EAST PRESTON PARISH COUNCIL

Re: recent planning documents

I would like to use Planning Application EP/48/21/HH as an example of the concerns the committee has. This Application was for 2 Bay Tree Garden, one of a cul-de-sac of just three properties.

Proposed Materials:
Roof Tiles - Black tiles t.b.c
Walls - Thermowood charred timber cladding and painted render
Dormer Walls - Thermowood charred timber cladding

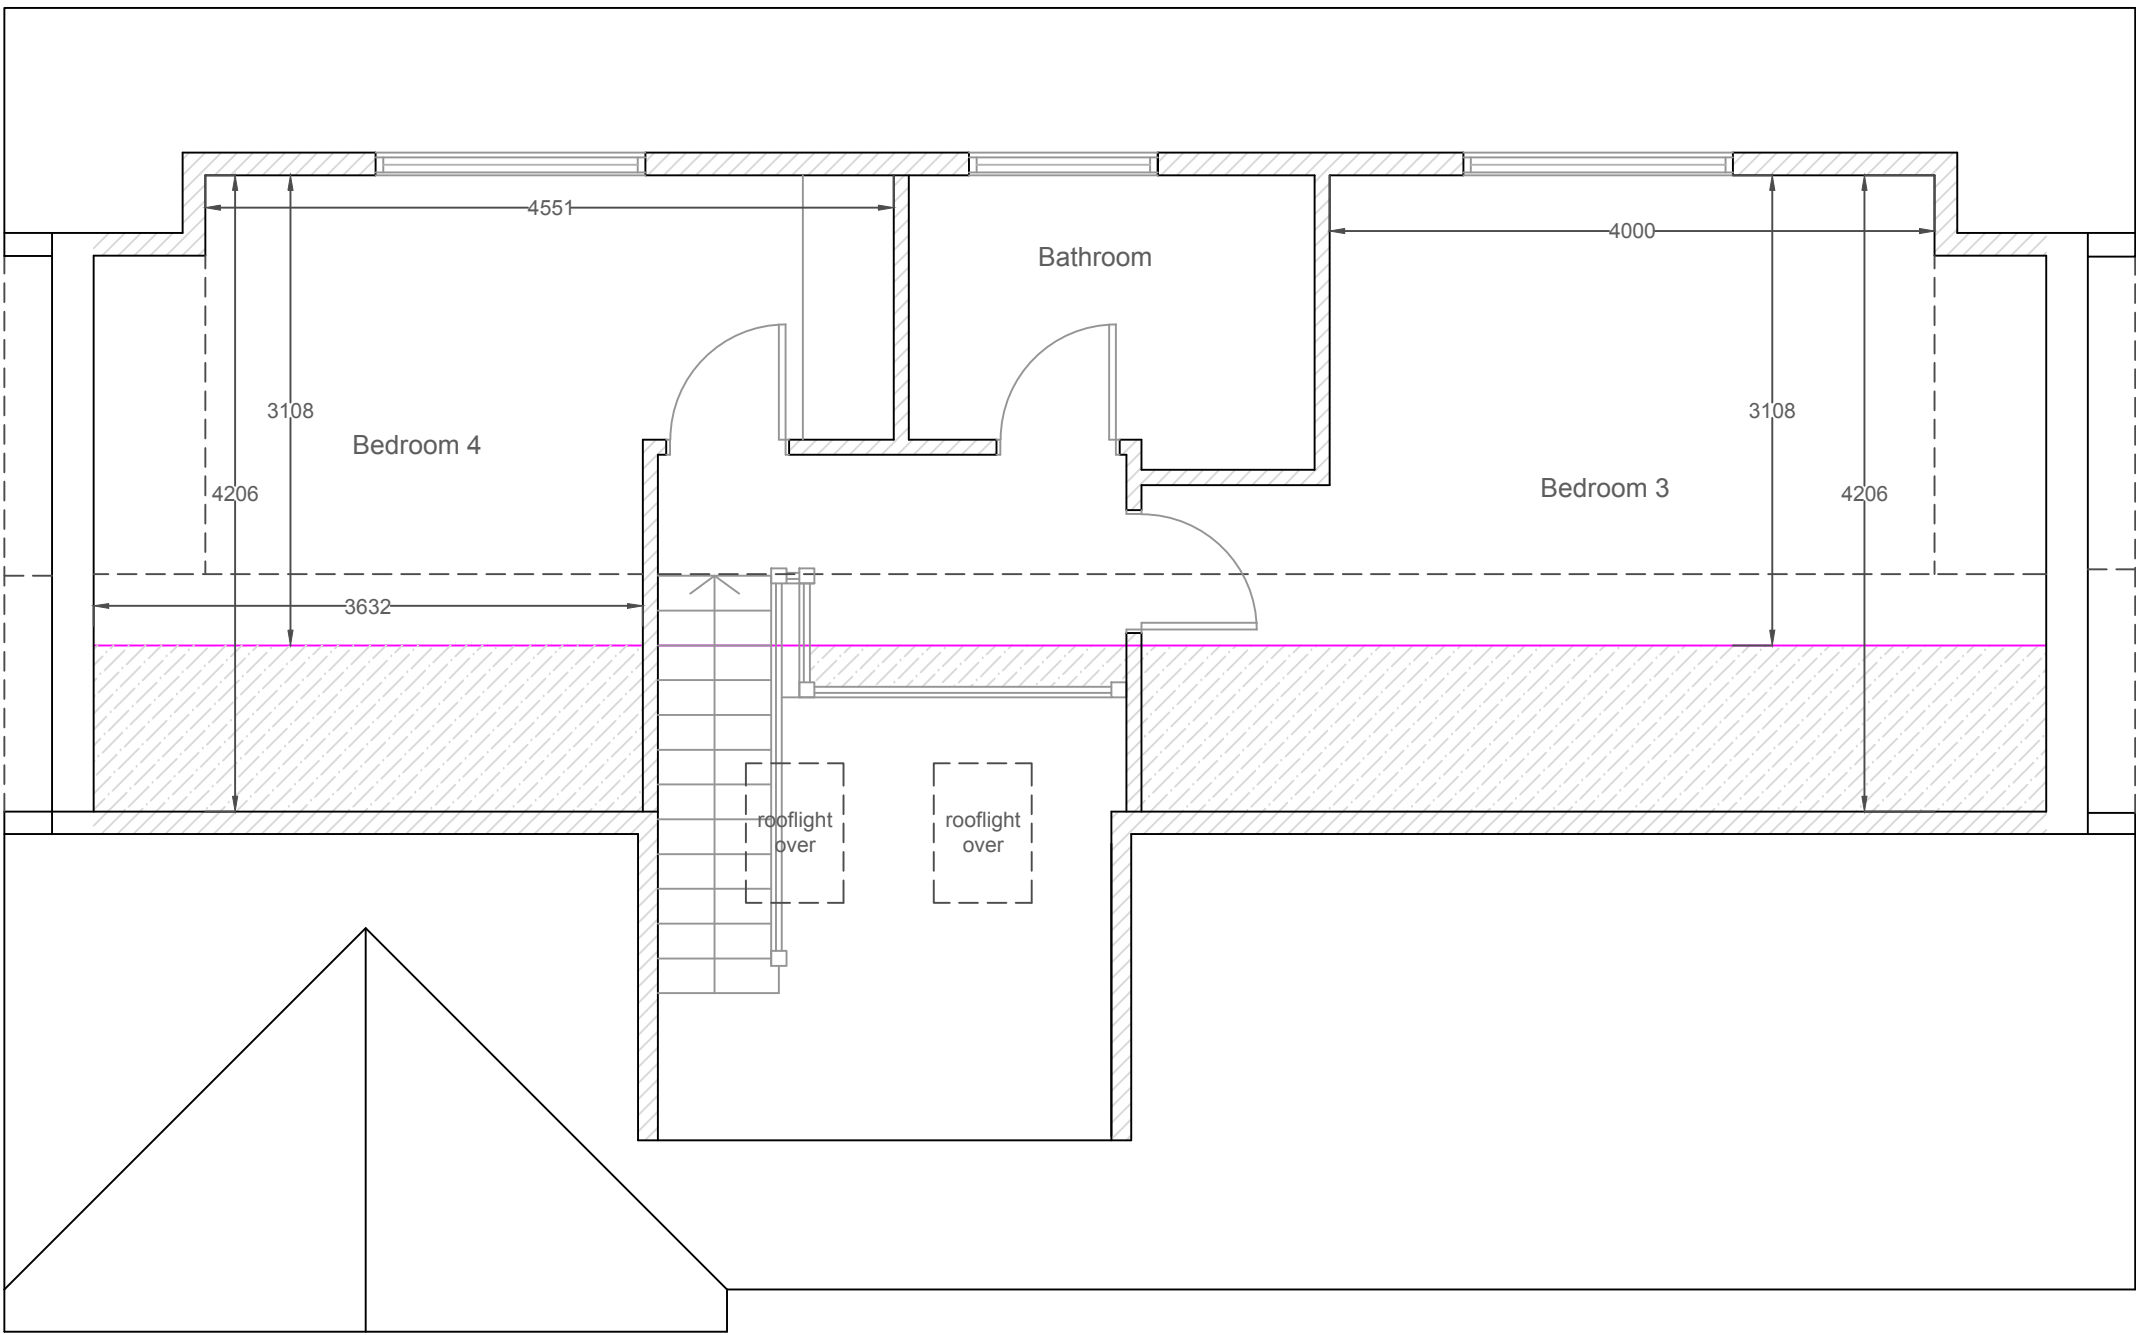
Starting with the Decision Notice, there is one item of especial concern. Condition 3 reads, "The dormer windows in the rear elevation of the dwelling for bathroom and two bedroom windows shall be glazed with obscured glass and non-opening above 1.7m." Unless we are very much misinterpreting this, these windows should be non-opening **BELOW** 1.7m, shouldn't they? In other decisions notices making this same point, the wording has indeed been "below 1.7m".

The Officer's response to the objection to materials was "Materials proposed (roof tiles) to match with host dwelling/ timber cladding is common material used for dormer extensions." This does not address the objections made, in that these materials, being a complete change from the original ones, would change the appearance of the house completely and would not therefore fit in with its neighbours in this tiny close.
